Recommendation Report for Planning Permission for Works or Extension to a Dwelling

REF NO: AW/100/20/HH

LOCATION: Southgate
Lincoln Avenue
Aldwick
PO21 3EJ

PROPOSAL: Loft conversion with hip to gable extension & dormer, single storey rear & side extension & render & cladding to extension.

REV	NOTES	DATE
 INTERIOR ARCHITECTURE + DESIGN		
PROJECT SOUTHGATE, Lincoln Avenue Rose Green, Bognor Regis		
DRAWING Proposed Plans & Elevations		
DRAWN BY JP	SCALE 1:50 @ A1	
DATE April 2020	REVISION	
DRAWING NO. 10025-DPA-003

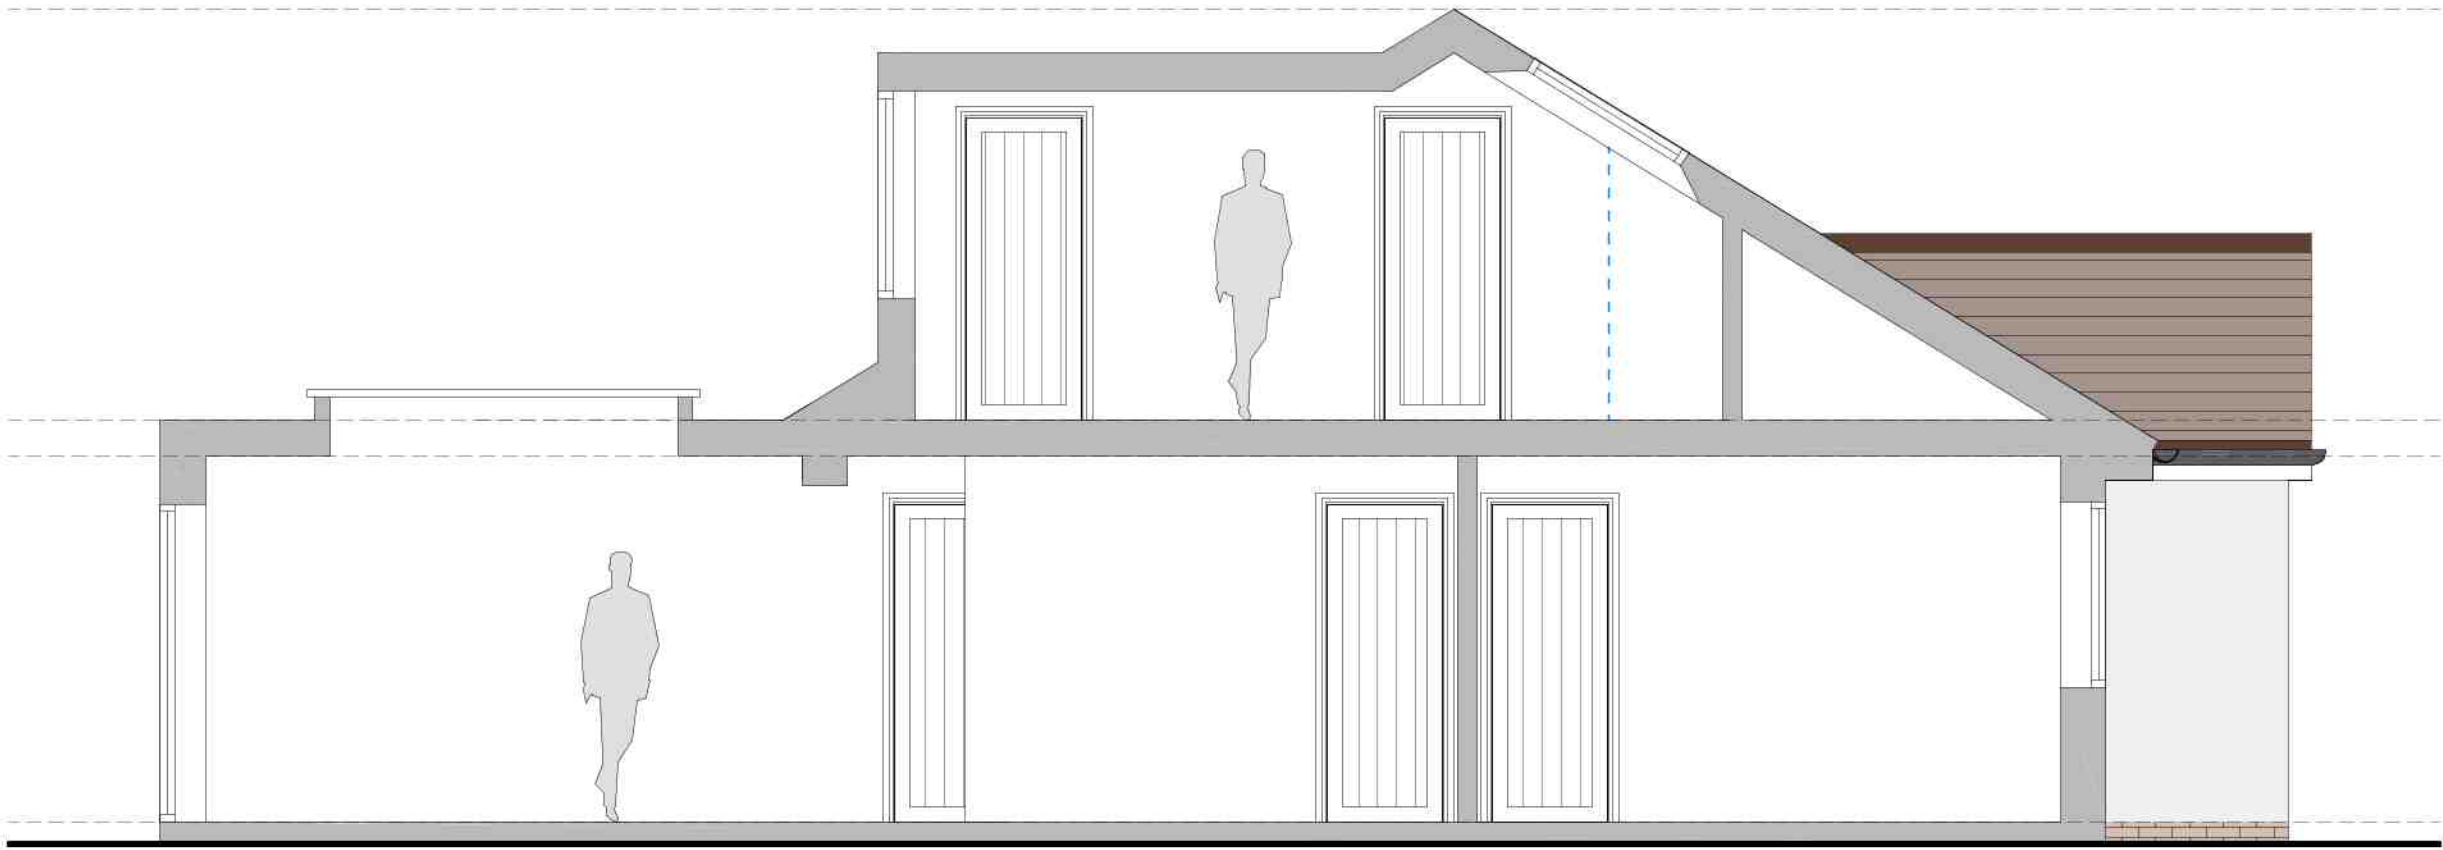
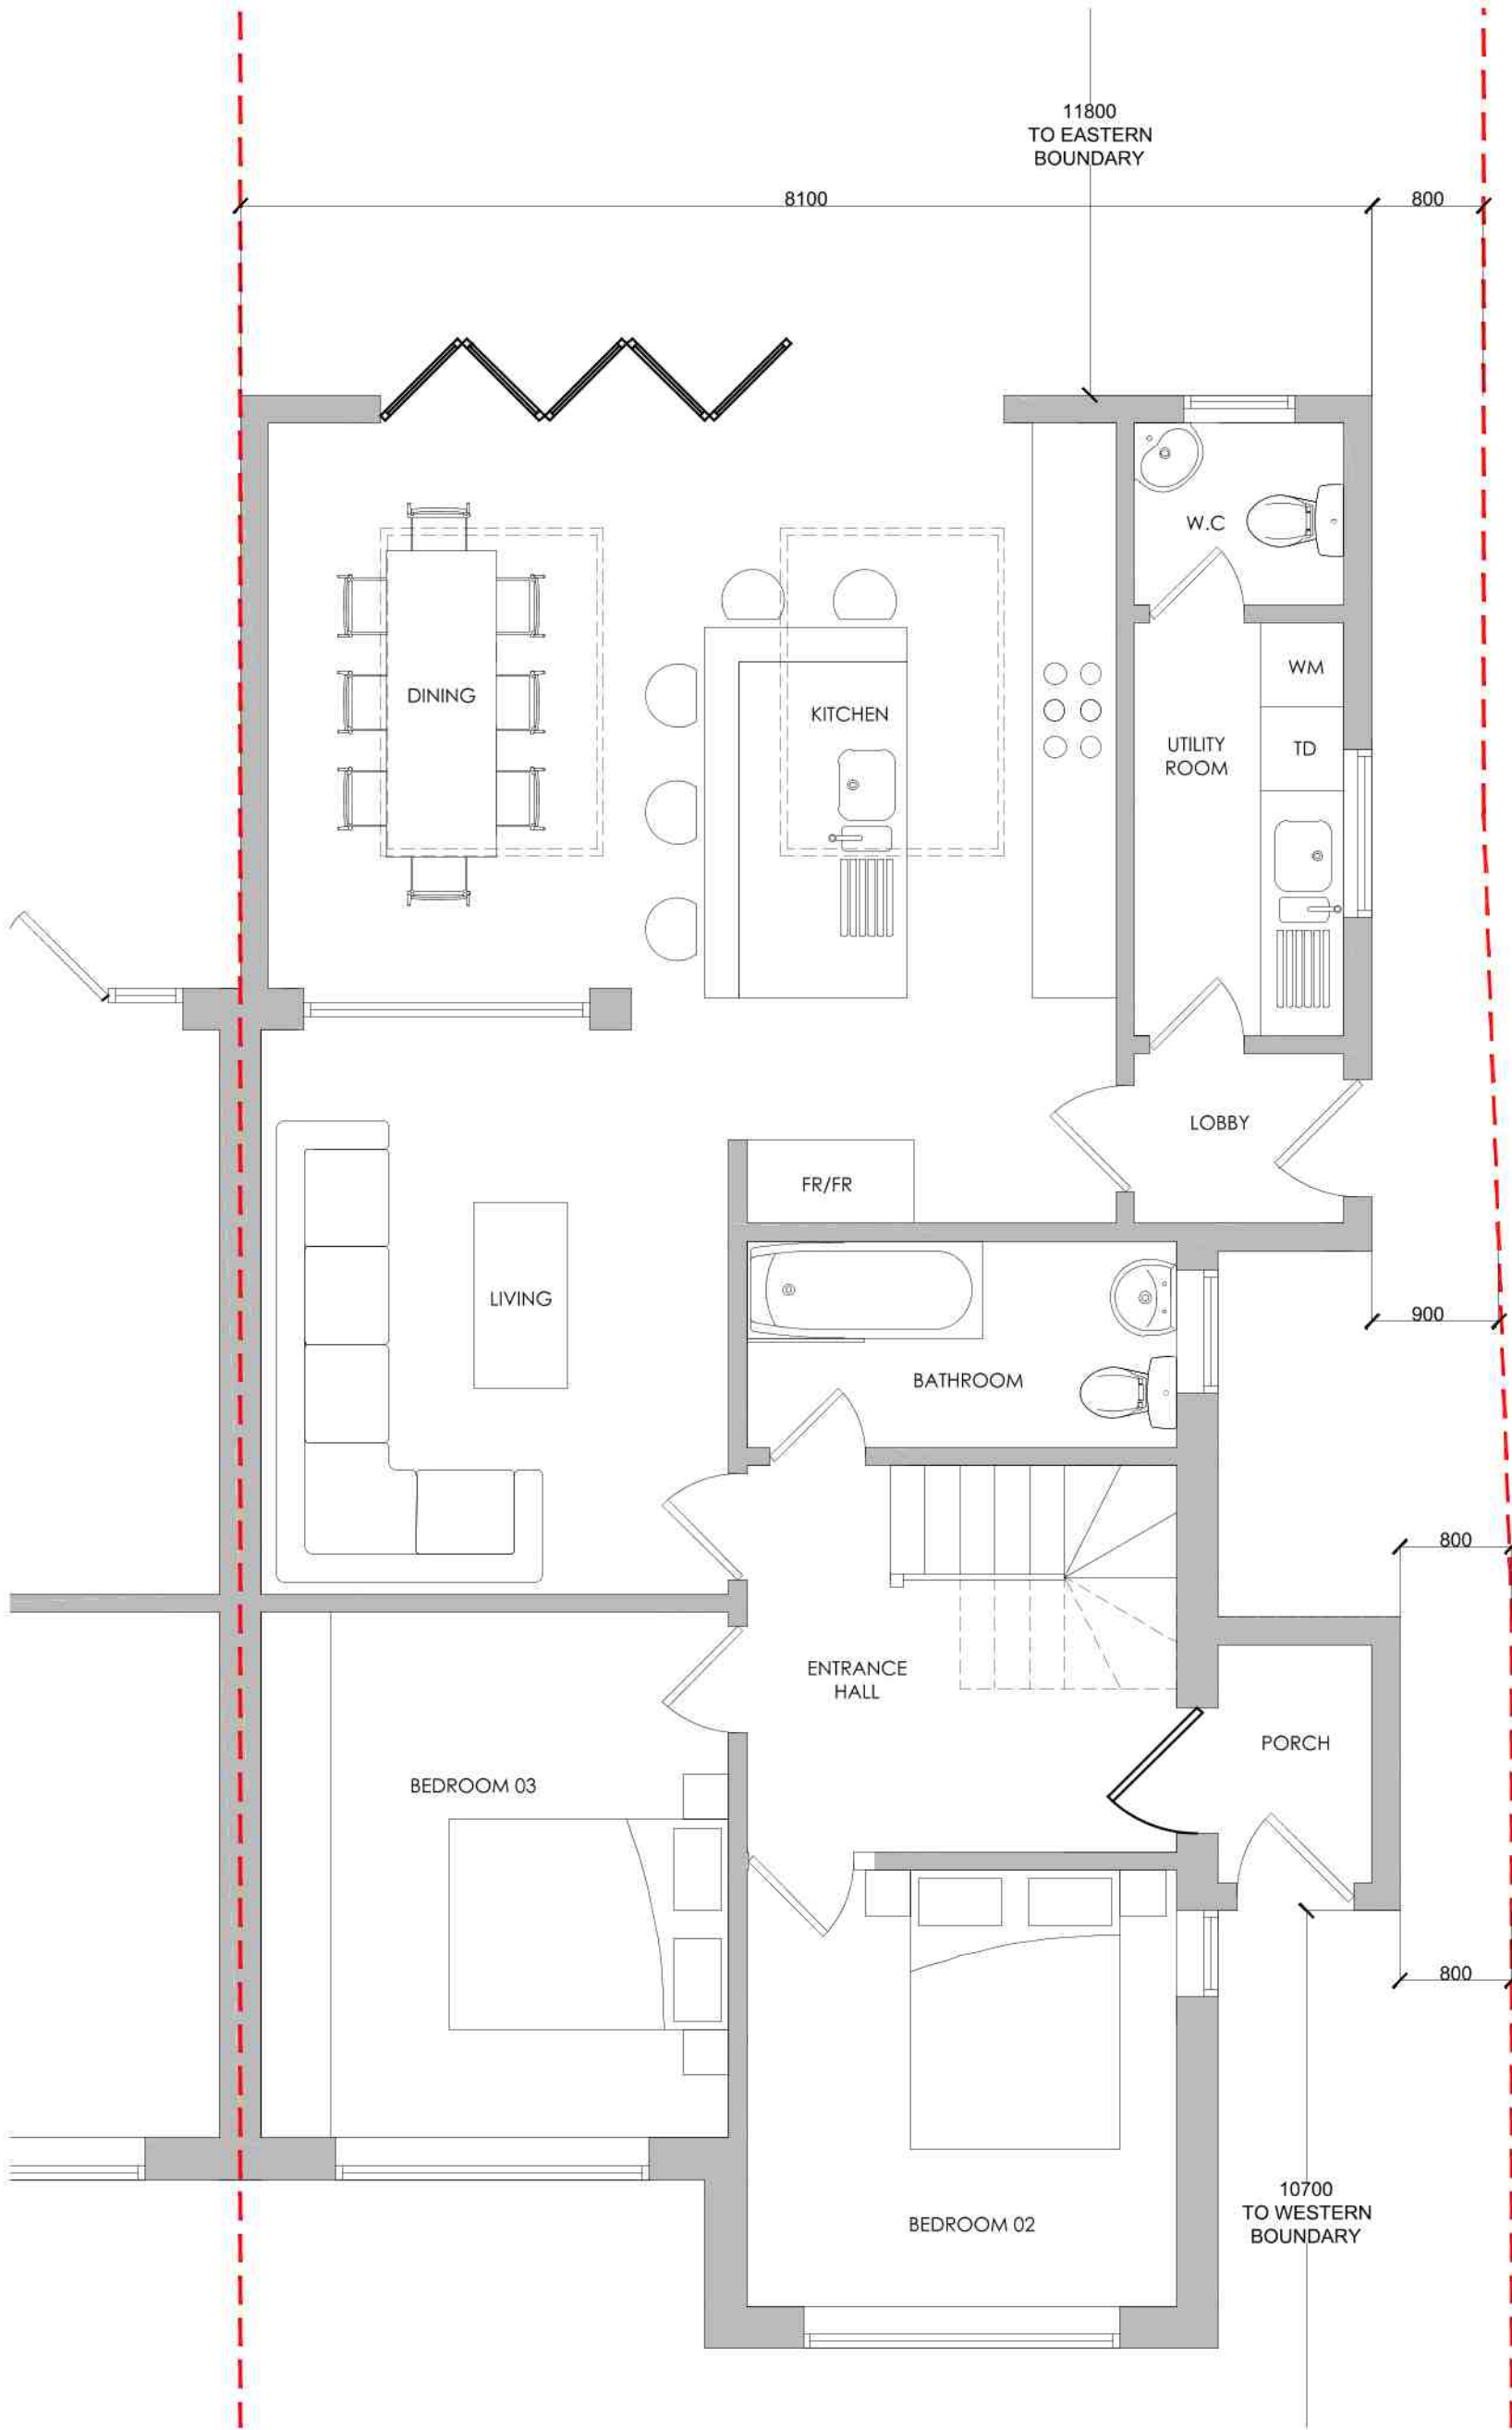
The proposal will alter the roof from hipped to a gable. The dwelling is constructed as a pair with the property to the north and the appearance will contrast this, however surrounding properties, whilst single storey vary in design with some examples of gables roofs and the alteration is not considered to result in the dwelling appearing significantly out of character for the area.

The alteration to the roof increases the ridge height by around 0.1m and due to the minor change, it is not considered to result in an adverse impact.

There is a lean to structure to the south elevation. This will be removed and replaced with a porch, which is well integrated and minor in nature.

Materials consist of clay roof tiles which match the dwelling and render. Cladding will be used to the side gables and rear however visibility of this is limited and the materials are acceptable.

The proposal will alter the roof design from hip to gable which will slightly increase height of the dwelling by around 0.1m. Due to the minor increase, it is not considered to result in the dwelling overbearing or overshadowing upon neighbouring amenity.

There will be the addition of a rear extension. There is a small gable projection to the rear of around 1.2m depth. This will be removed and replaced with an extension which runs along the full rear of the dwelling with a depth of 4.25m and extending beyond the side elevation by 1m and wraps around to the southern side with a depth of 1.85m. The extension will have a flat roof with a height of 2.7m.

This is considered to intersect a 45 degree angle when drawn from the neighbouring window closest to the shared boundary. However a 3m extension could be constructed under permitted development which is also considered to intersect this and the additional depth is not deemed to give rise impacts significant to that which would be permitted. The neighbouring property has provided no objection to the scheme. It is not considered to provide adverse overbearing or overshadowing impacts.

A rear dormer will be constructed. This is fairly modest in size retaining around 0.8-1m to the side elevations of the roof slope. This will have a depth of 3.1m and height of 2m and is not considered overbearing with the development retained within the existing roof slope. The windows will provide additional overlooking to neighbouring properties but not significantly above that which could be achieved as permitted development.

There will be doors to the rear and an additional window to the south elevation. With these at ground floor level, it is not considered to give rise to adverse overlooking with sufficient fencing in place also.
